**From:** Simon Davis  
**Sent:** 03 January 2018 15:59  
**To:** Planning Scanning  
**Subject:** FW: AL/129/17 Forge House

Location and Site Plans

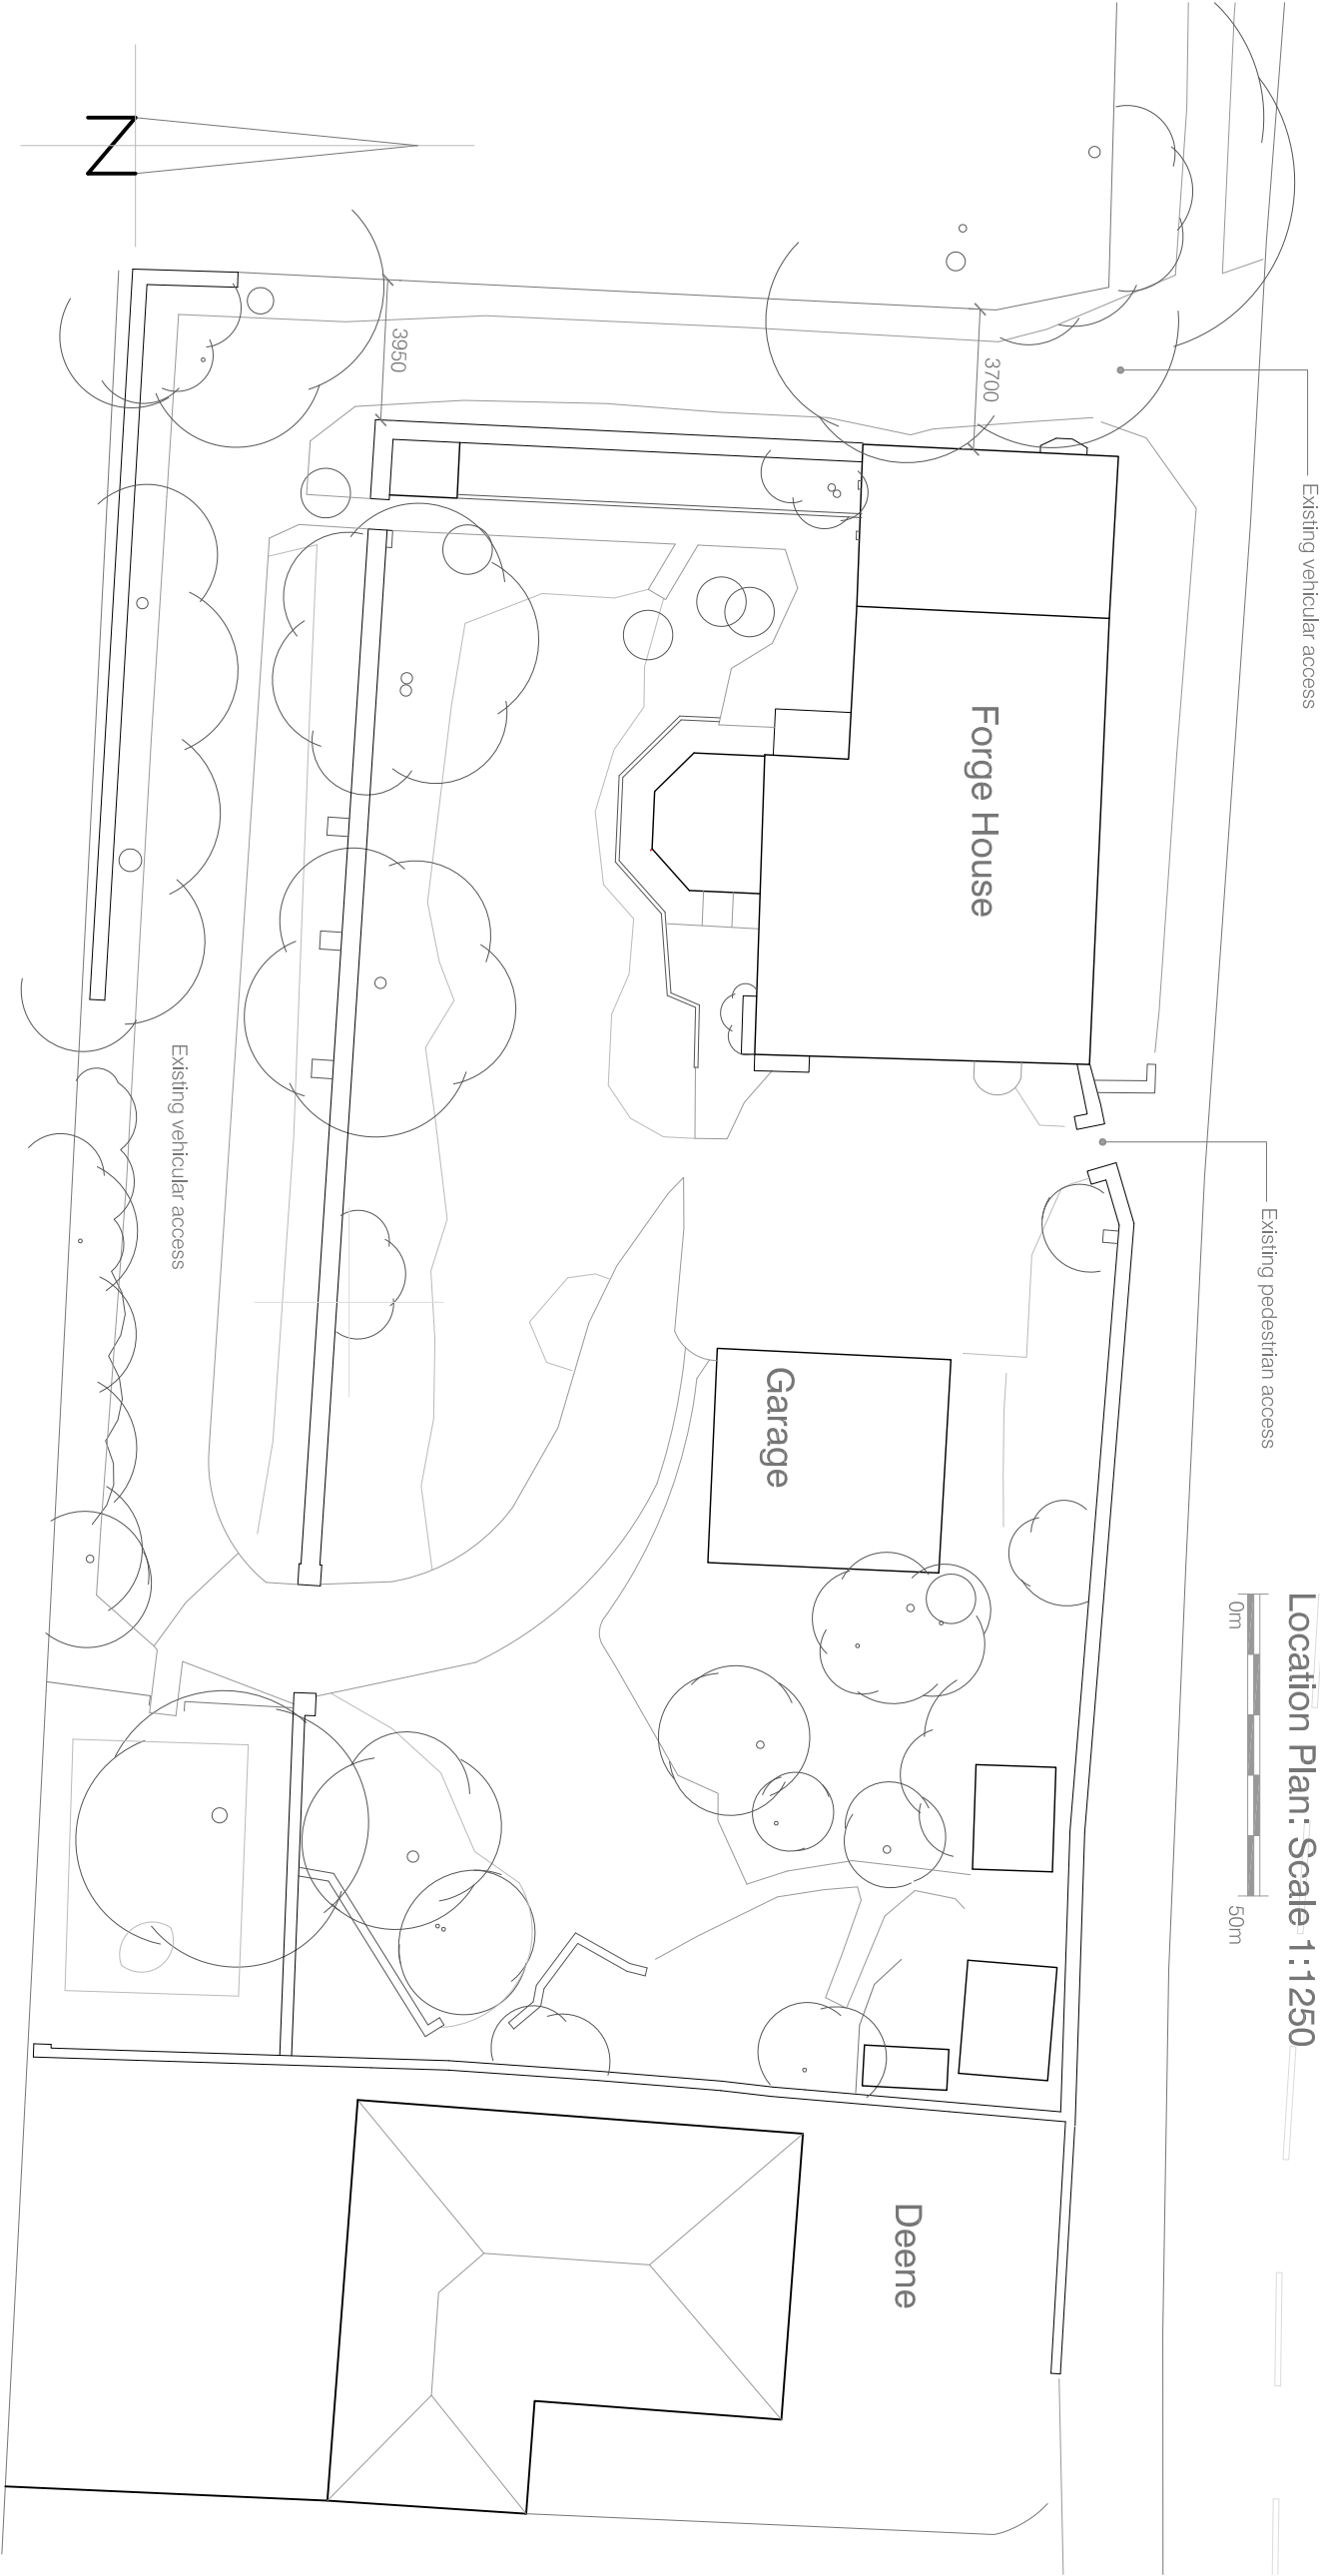
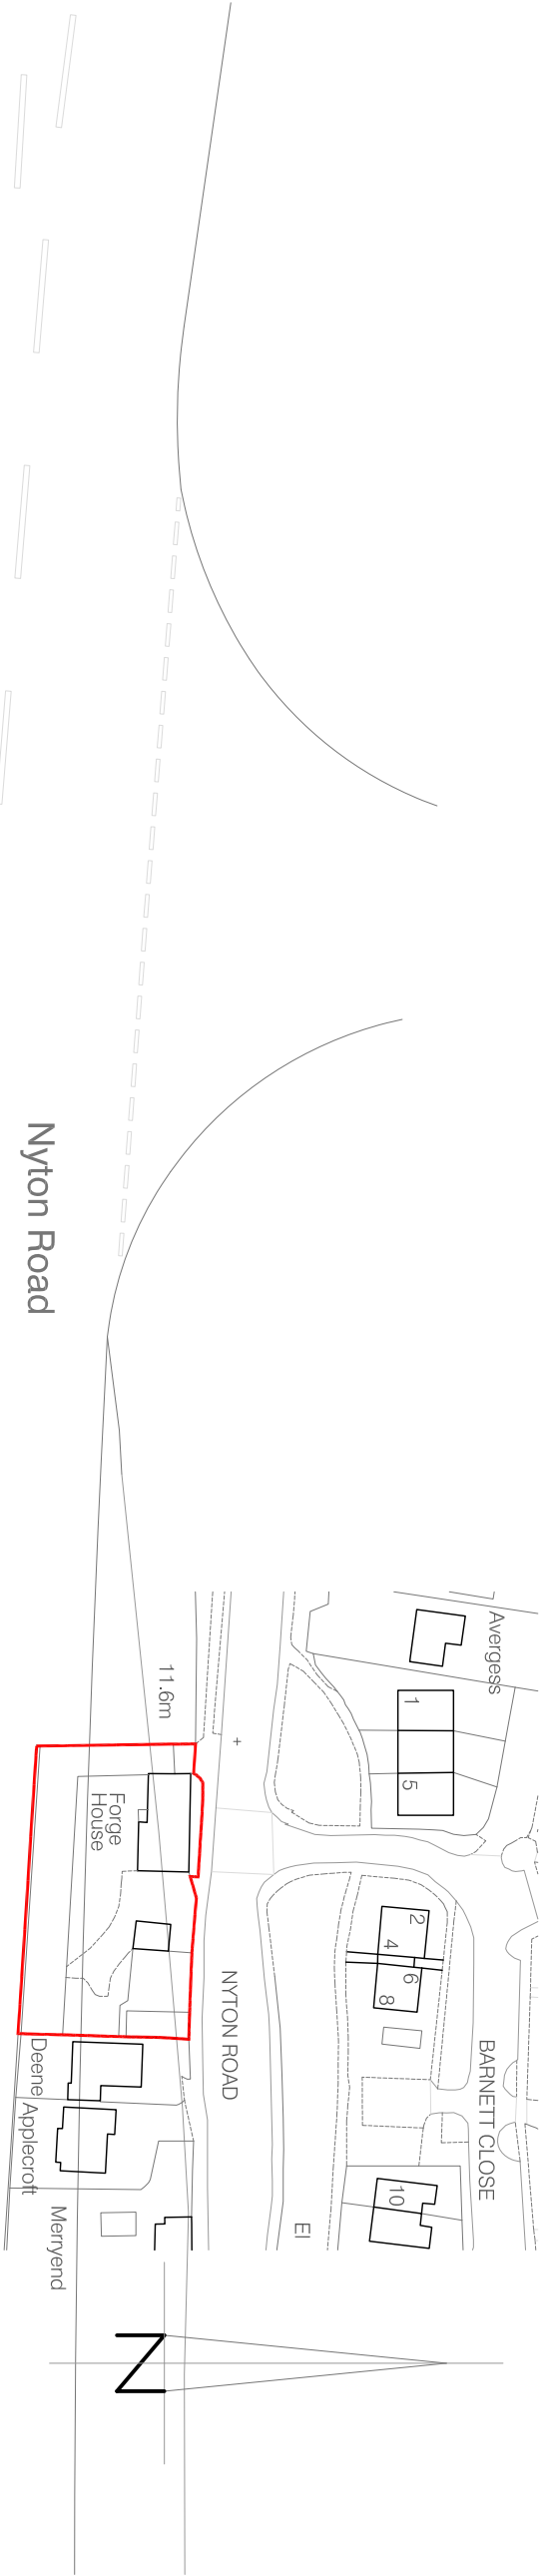
The Conservation Officer was referring to the removal of the wall which is within the site. I have annotated an existing site plan to indicate which wall she is referring to.

I have read the comments from the Conservation Design Officer and it is factually incorrect. It states, "*the proposals detail removal of 24 linear metres of walling to create vehicular access*". The access is existing and no new vehicular access is proposed.

Thank you for the clarification, this walling cannot be seen from a public vantage point and does not make a significant contribution to the street scape or surroundings, particularly as it is not a listed building. The integrity of the house and walling are maintained by the retention of walling within the front elevation in Westergate Street in accordance with the Neighbourhood Plan and the paragraph 128 of the NPPF.

With regard to landscaping, an existing garage is proposed to be demolished and car parking is proposed to replace it, the existing hardstanding adjacent to the house will remain as existing. Therefore there is no significant additional hardstanding proposed. It is proposed to remove sheds from the existing garden and the landscaping will remain at the front of the proposed houses therefore landscaping seen from the street scene will remain as currently seen over the wall, which is to remain.

project			
Forge House			
Nyton Road			
Eastergate West Sussex			
drawing			
Floor Plans and Indicative			
Street View			
As Proposed			
scale	date		
1:100, 1:125 @ A3	October 2017		
job no	drawing no	rev	
16078	02.02	A

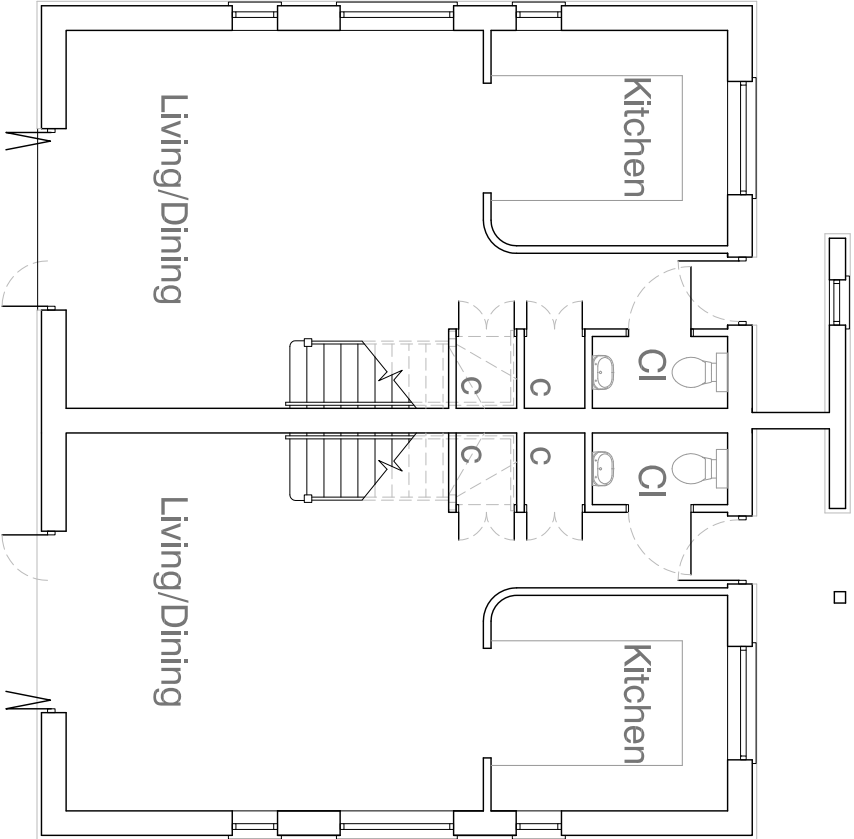
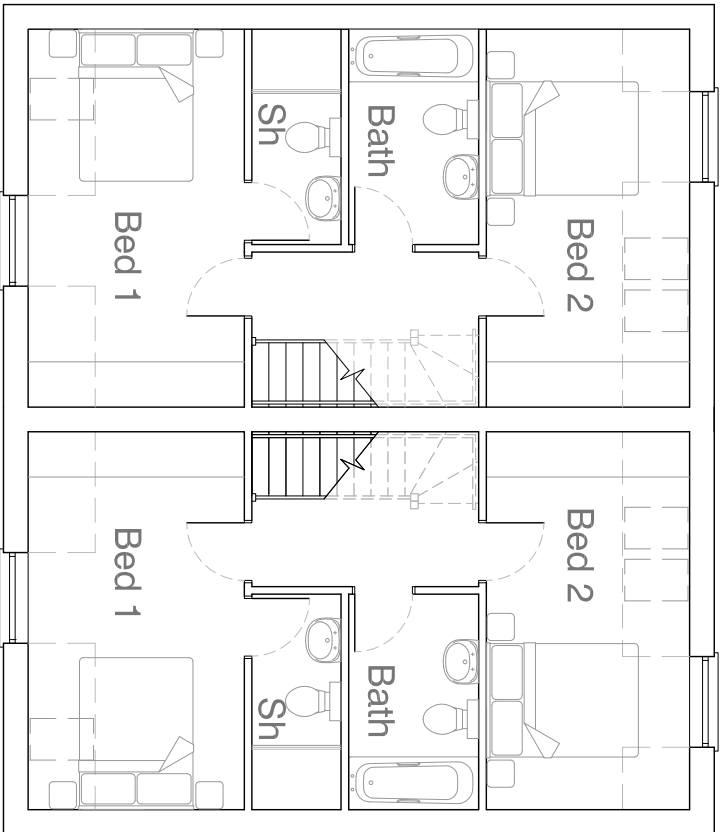
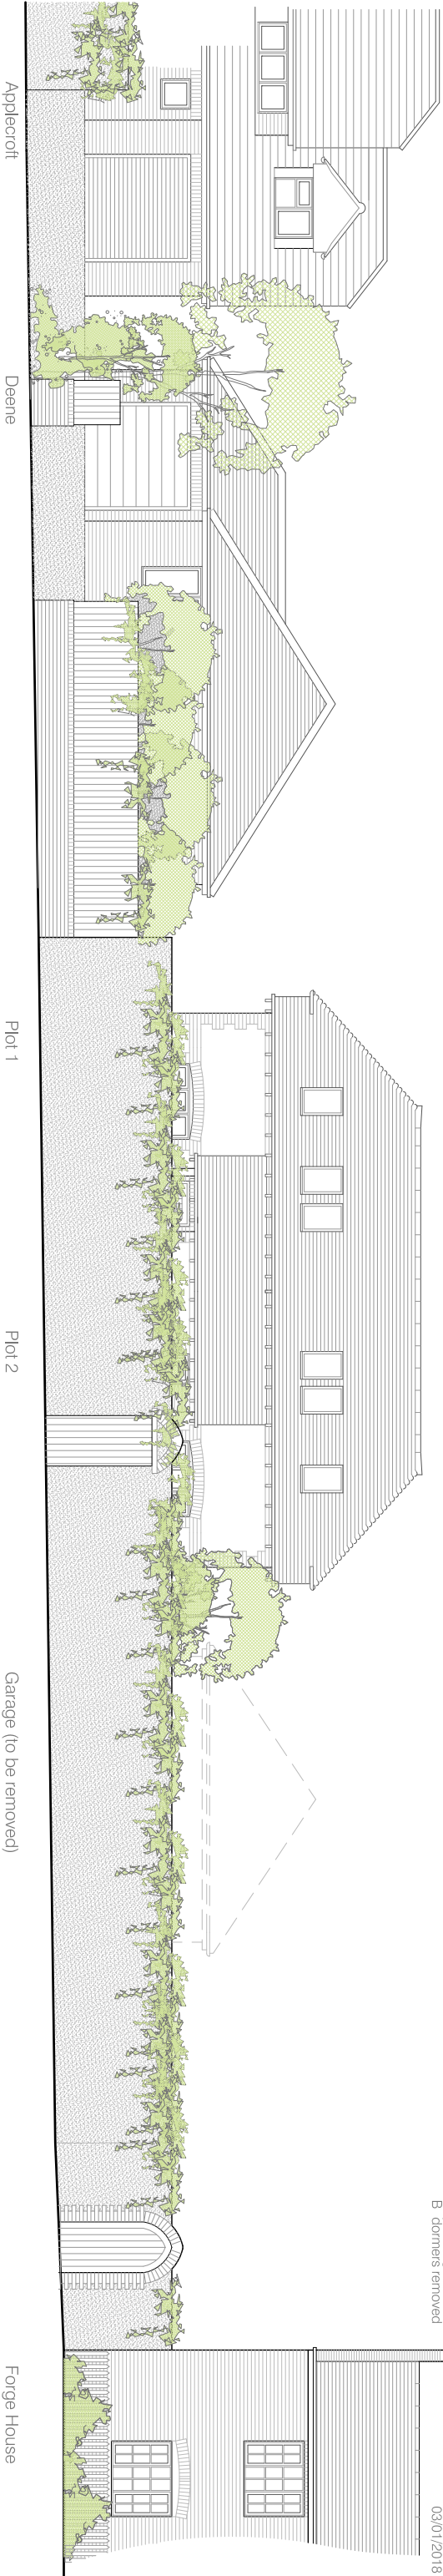
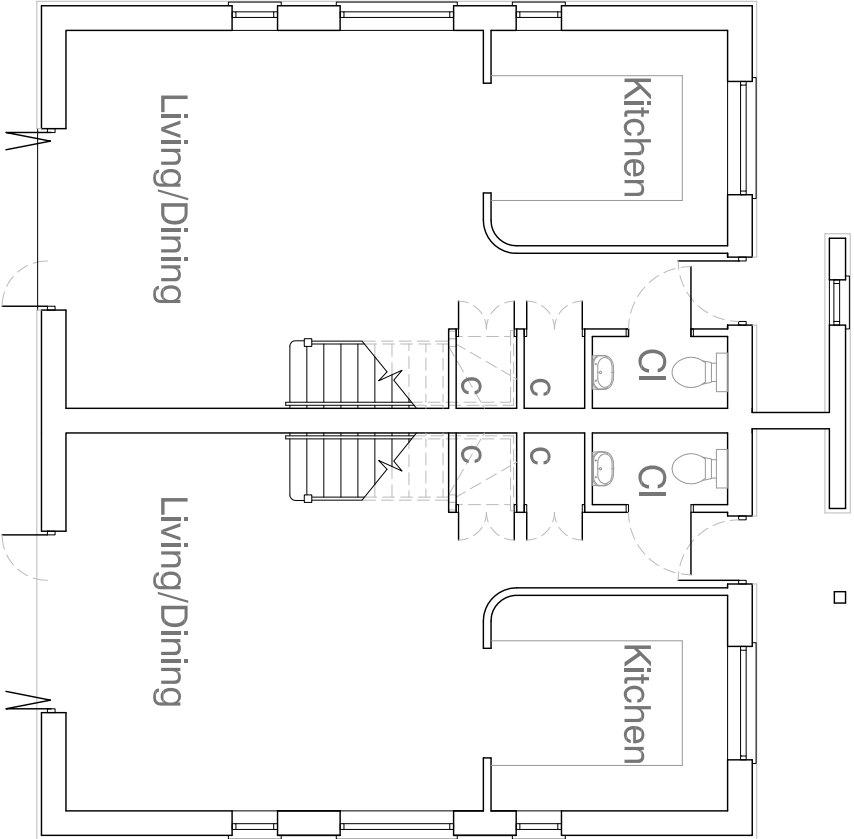
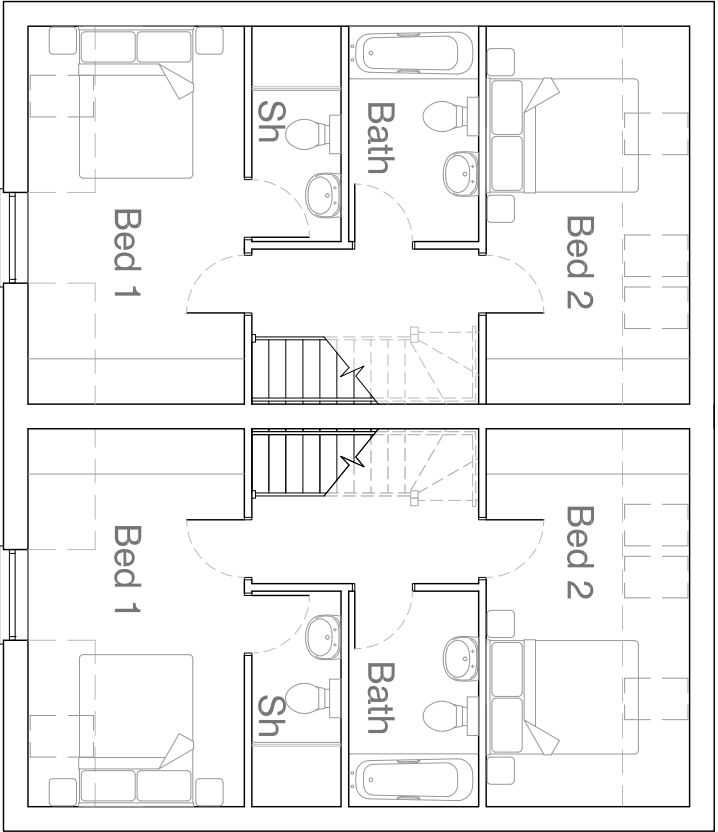
We have looked at the appearance within the street scape of the proposed new building and in accordance with the comments of the Design Officer, we are proposing to remove the front dormers to provide a less dominating roof scape. The revised plan will be with you as soon as possible.
